LIME DOWN SOLAR PROJECT

**DEADLINE 2 COMMENTS
STOP LIME DOWN**

22 May 2026

Title:
Figure 9-9-6: Watercourse Crossing
Schedule: Cable Route Corridor

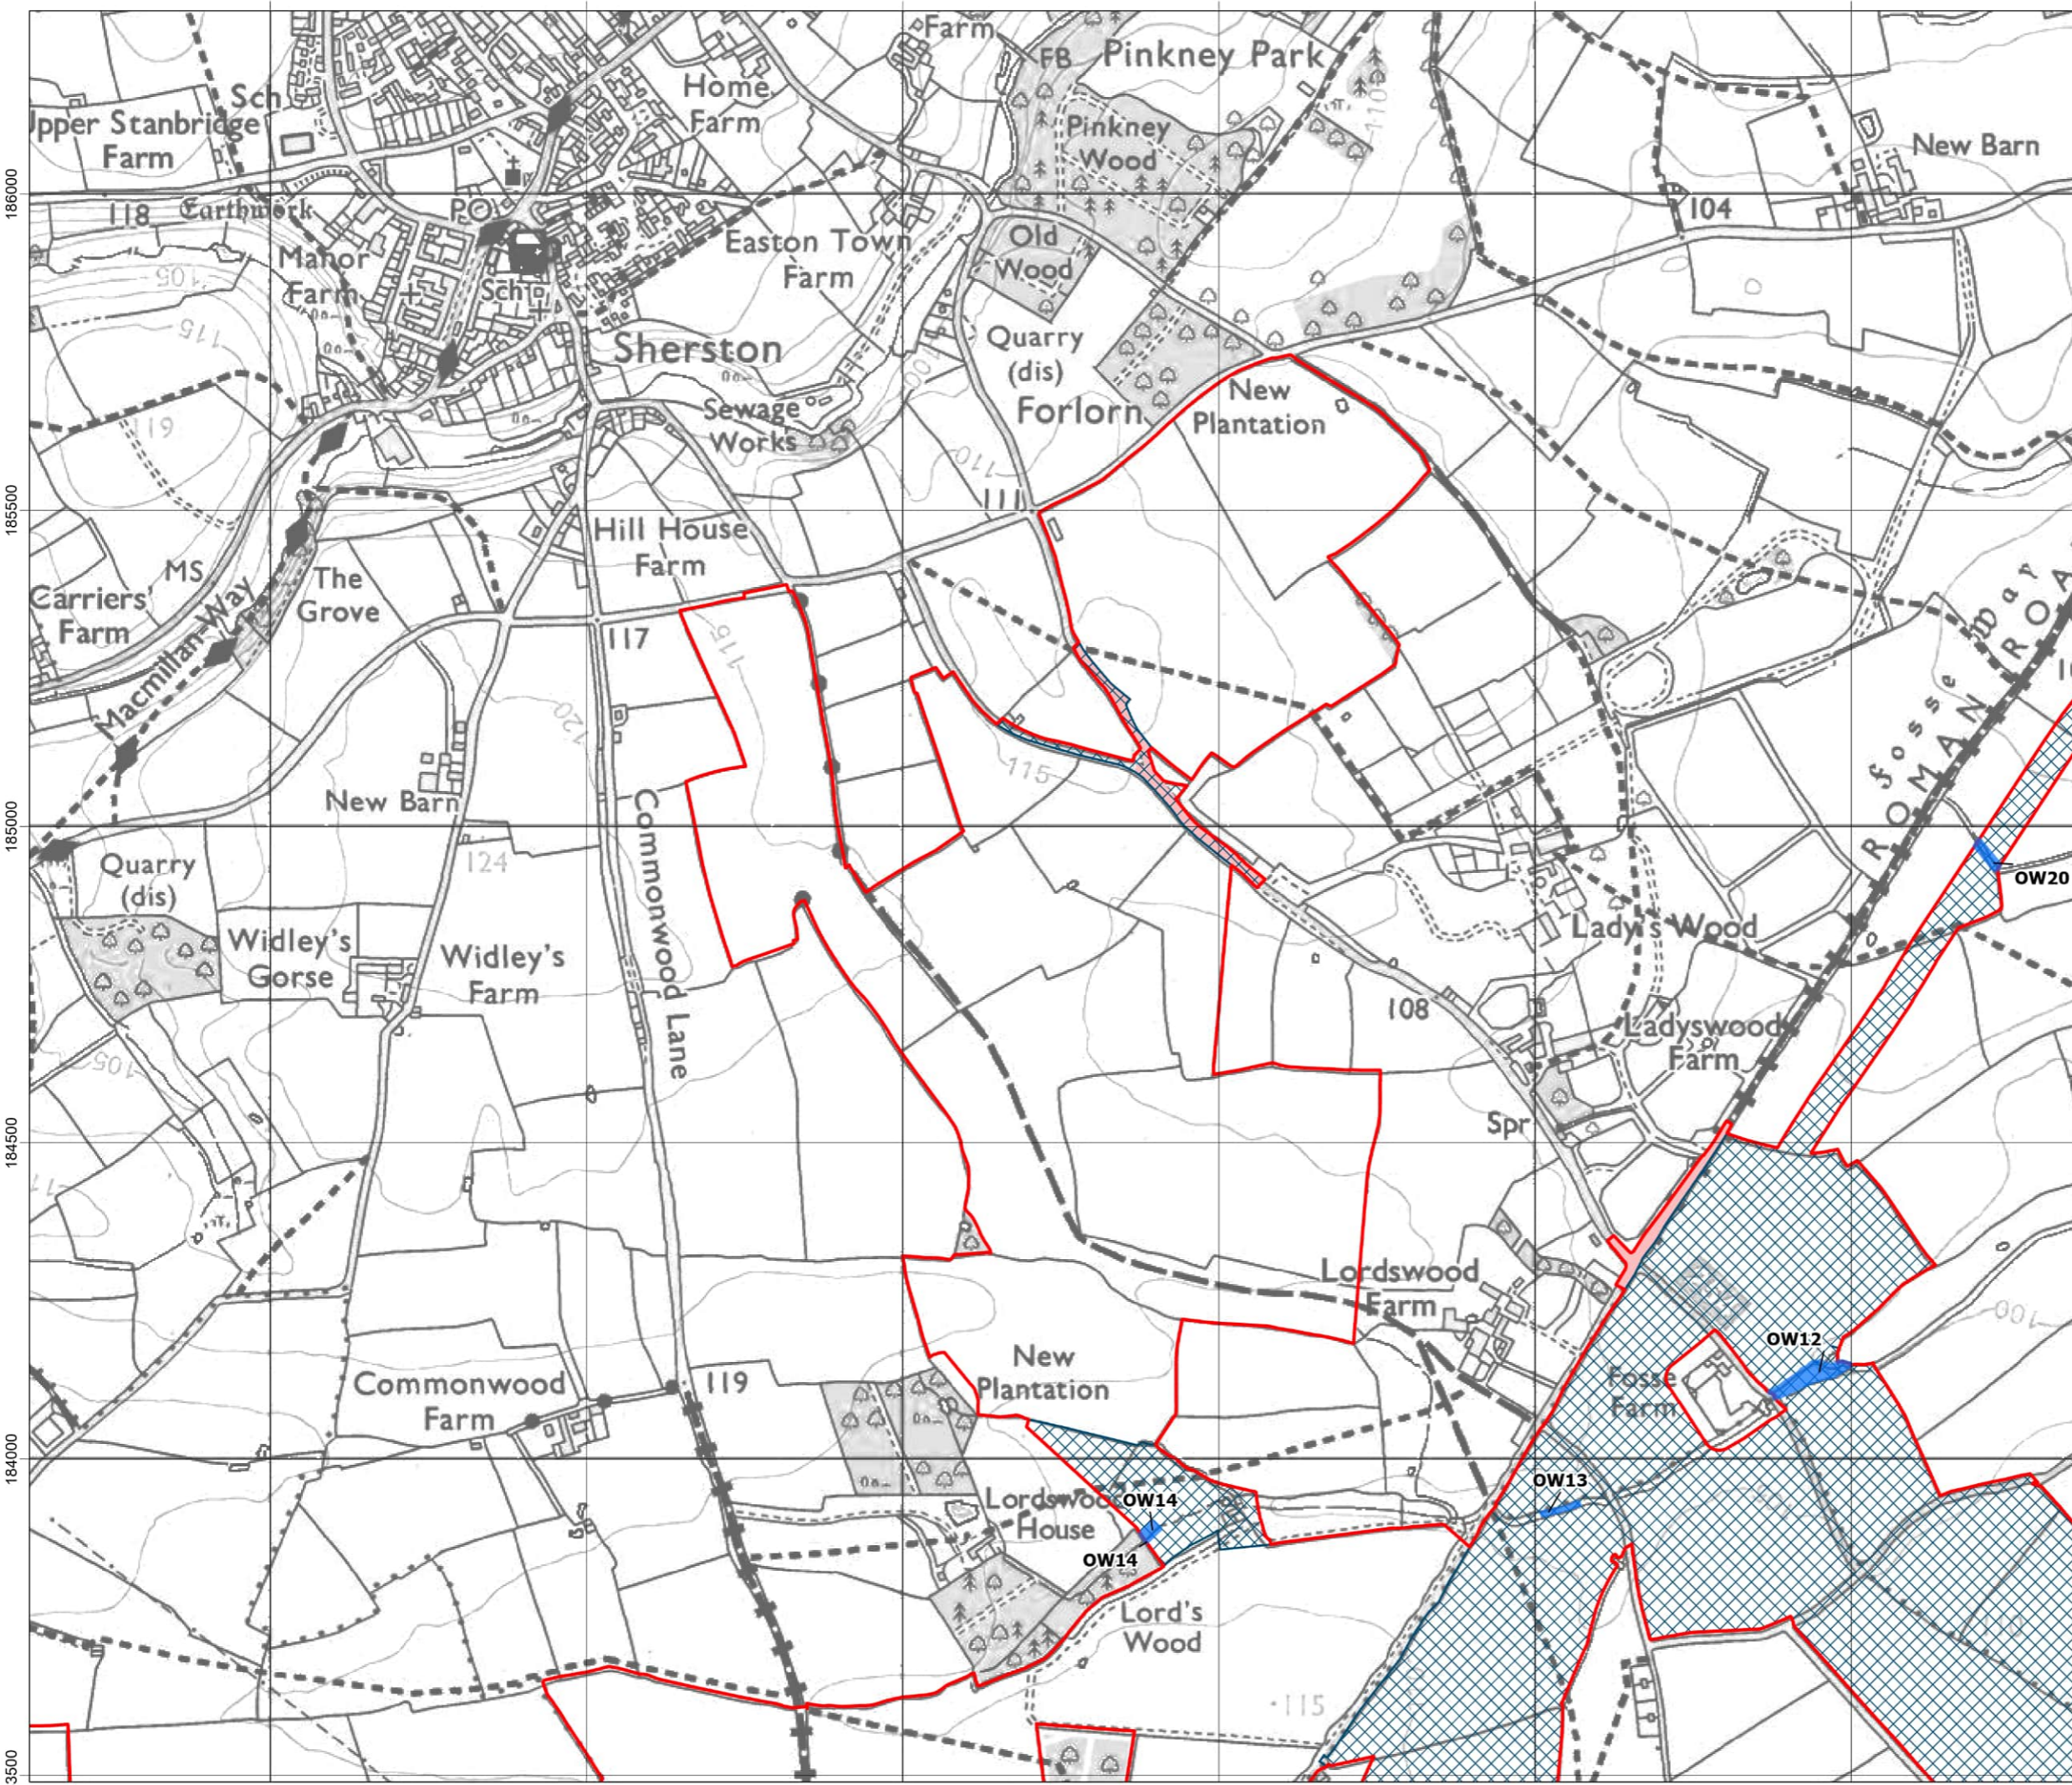
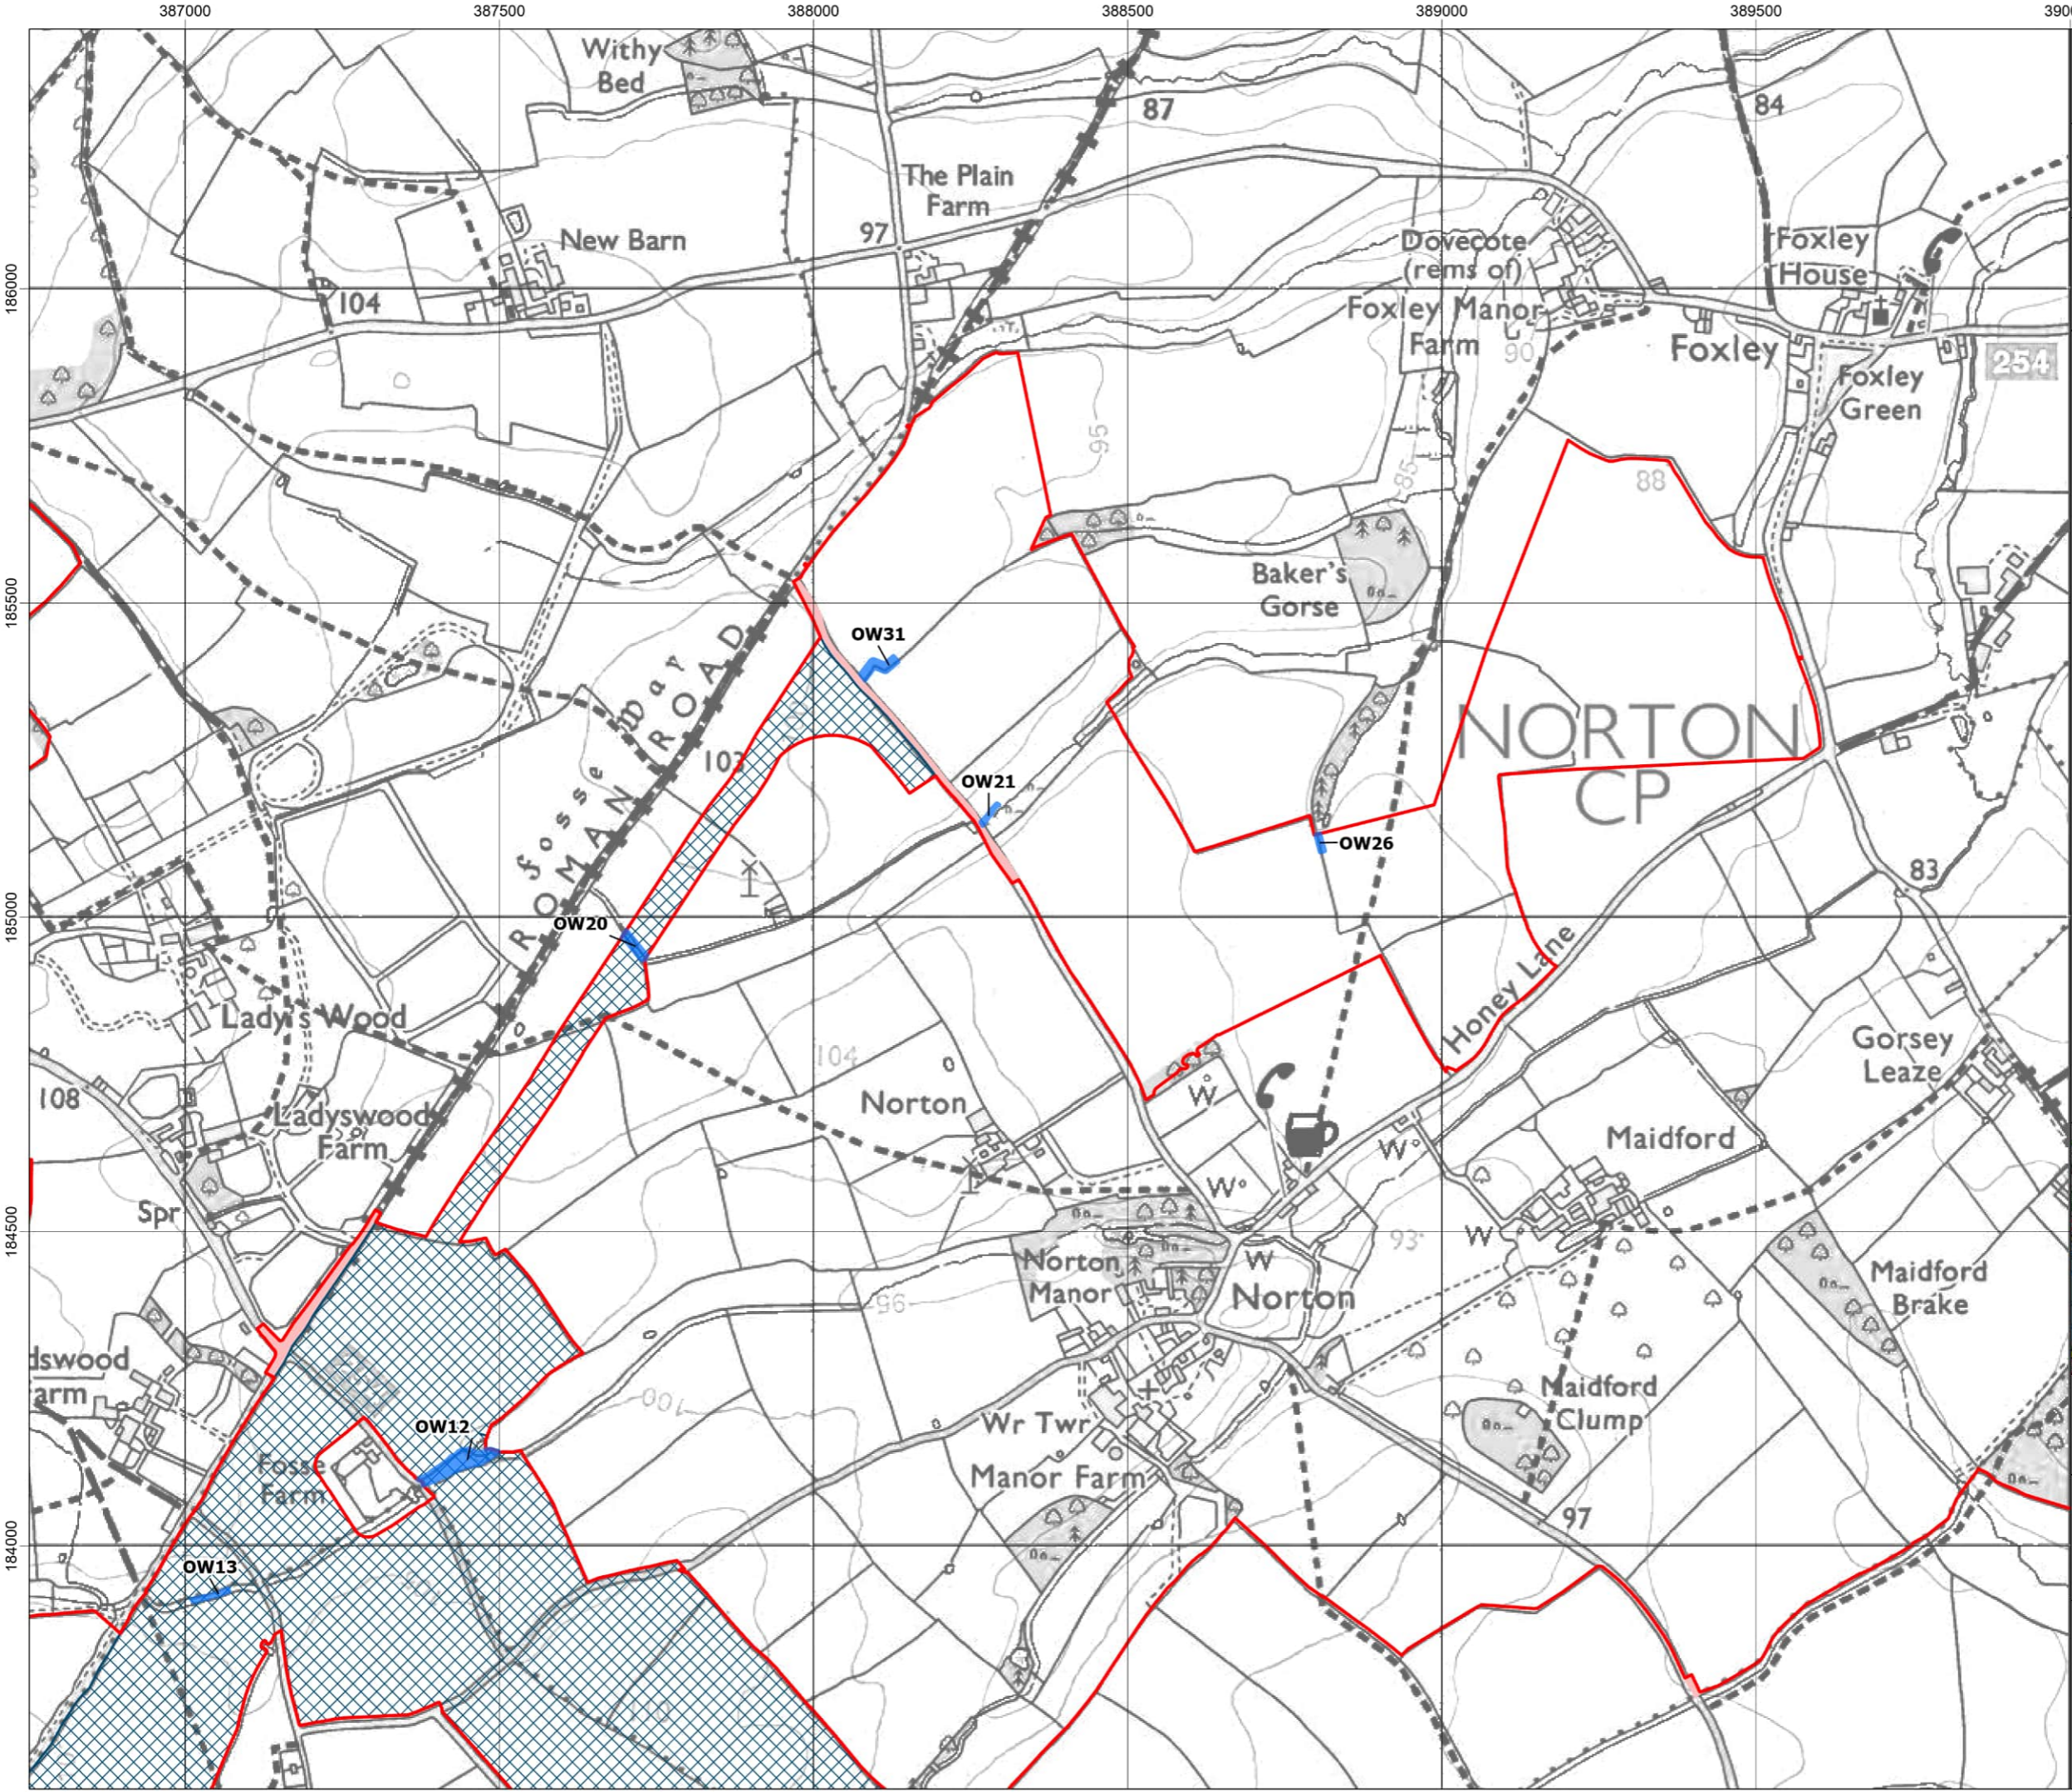
- 2.6.2.1. Minimal changes have been made to the site-specific FRAs and covering report;
- 2.6.2.2. The Firewater Containment Report does not address the credible worst-case scenario of a BESS fire taking more than 4 hours to extinguish;
- 2.6.2.3. It is unclear whether the Watercourse Crossing Schedule is exhaustive and the Schedule would benefit from an accompanying map; and
- 2.6.2.4. The Water Framework Directive Assessment is lacking in necessary detail.
